Q.5.4.0.1 Projects included in cumulative impact assessment

Answer 5.4.0.1 Oulton Parish Council

13 APPENDIX 6 SCHEME OF HIGHWAY MITIGATION (B1145, CAWSTON)

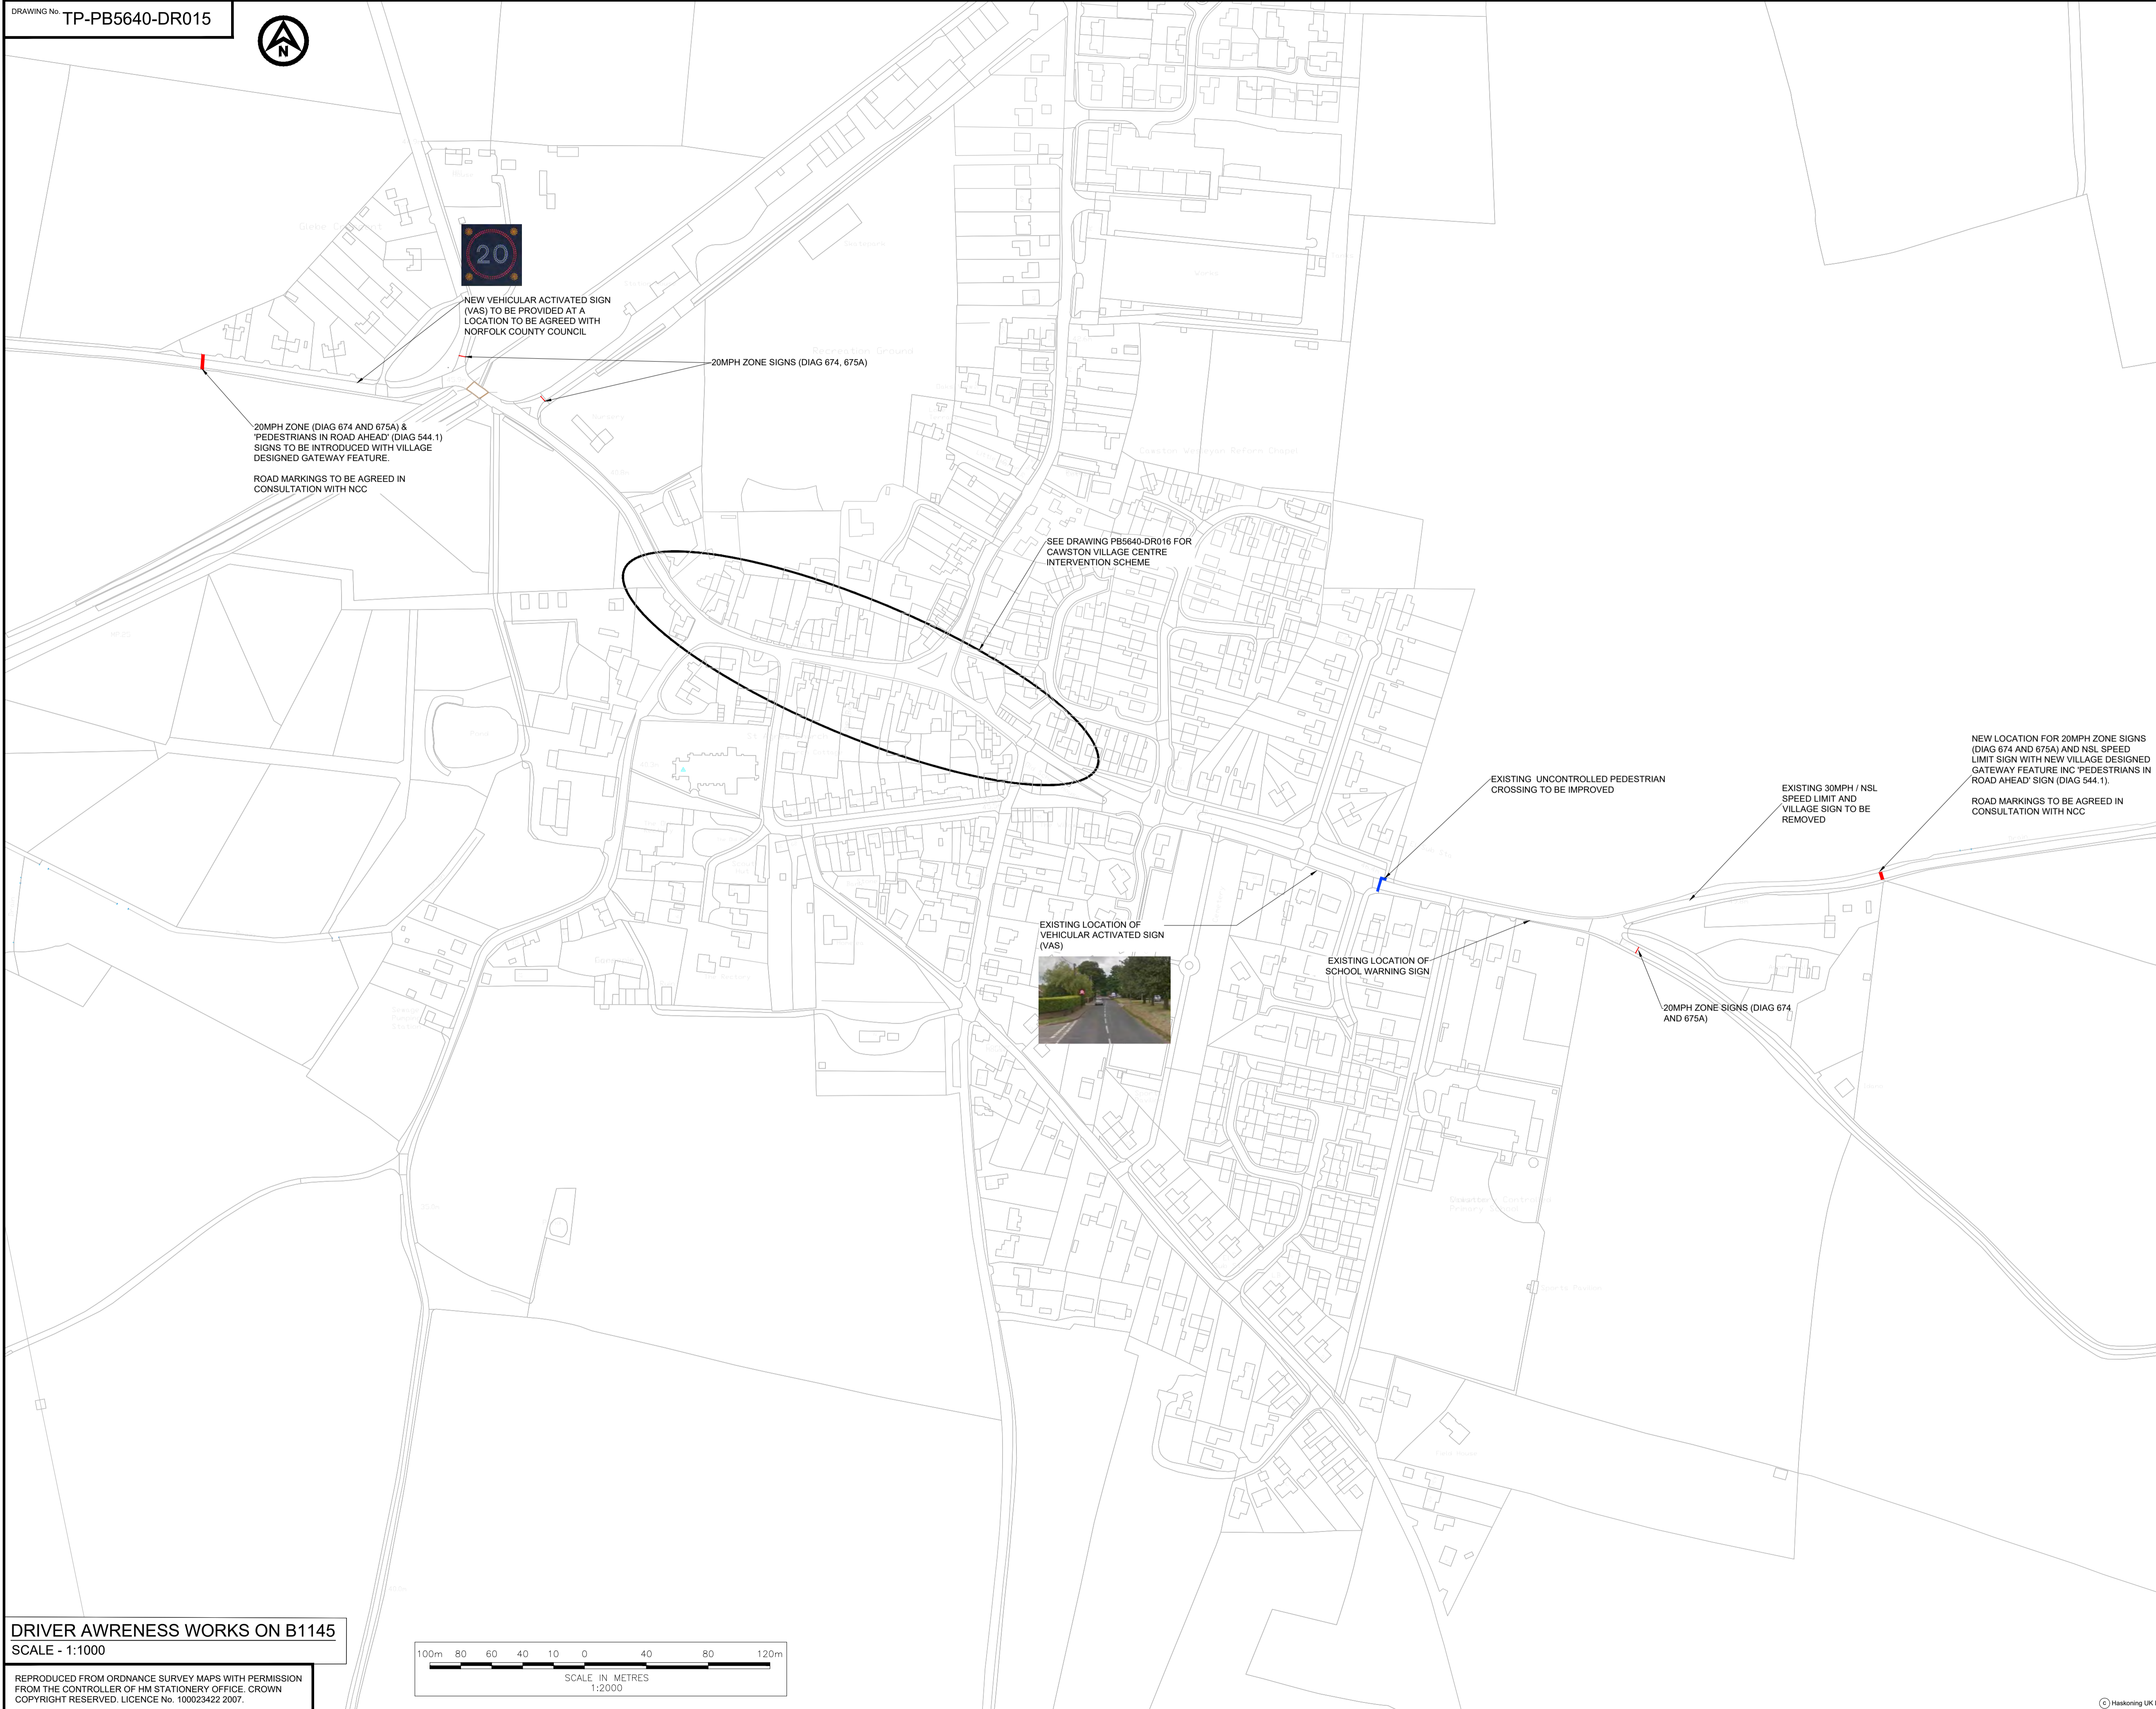
b) Requirement 16. trench-less crossing of B1149

OPC feels there is still some confusion as to whether the new requirement for a trench-less crossing is only required if Hornsea Three proceeds to construction, or if the requirement is irrespective of HOW3.

The implication here is that trenchless crossing might NOT be required if HOW3 does not go ahead.

OPC query the wisdom of this, as it was **NCC** who were concerned about the integrity of the road, post trenching work, under any circumstances.

If HOW3 does not proceed there remains an issue of very large agricultural traffic regularly using the B1149 during trenching work, which would have difficulty manoeuvring around the road works (combines, potato harvesters, pea viners etc.).

Norfolk Boreas is still proceeding with Scenarios 1&2 so there is still the need to consider Vanguard/Boreas Scenario 1 or Scenario 2 as well as Boreas Scenario 1 with SEP/DEP. The Applicant has consistently under-estimated the importance of the B1149 as a radial route from Norwich to the coast, and OPC feel that the trench-less crossing should be included in the DCO, regardless of whether it is in combination with HOW3 or is a standalone project.

In any case, NCC Highways has always strenuously maintained that it would be ill-advised to disturb the integrity of the substructure of the road by trench-cutting as, given the volume of heavy and agricultural traffic, the road surface would be liable to subsidence thereafter.

(t) In circumstances where the Hornsea Three Off-shore Wind Farm Development Consent Order is made and its development commences, there shall be trench-less crossing of the B1149 (Work No. 6).
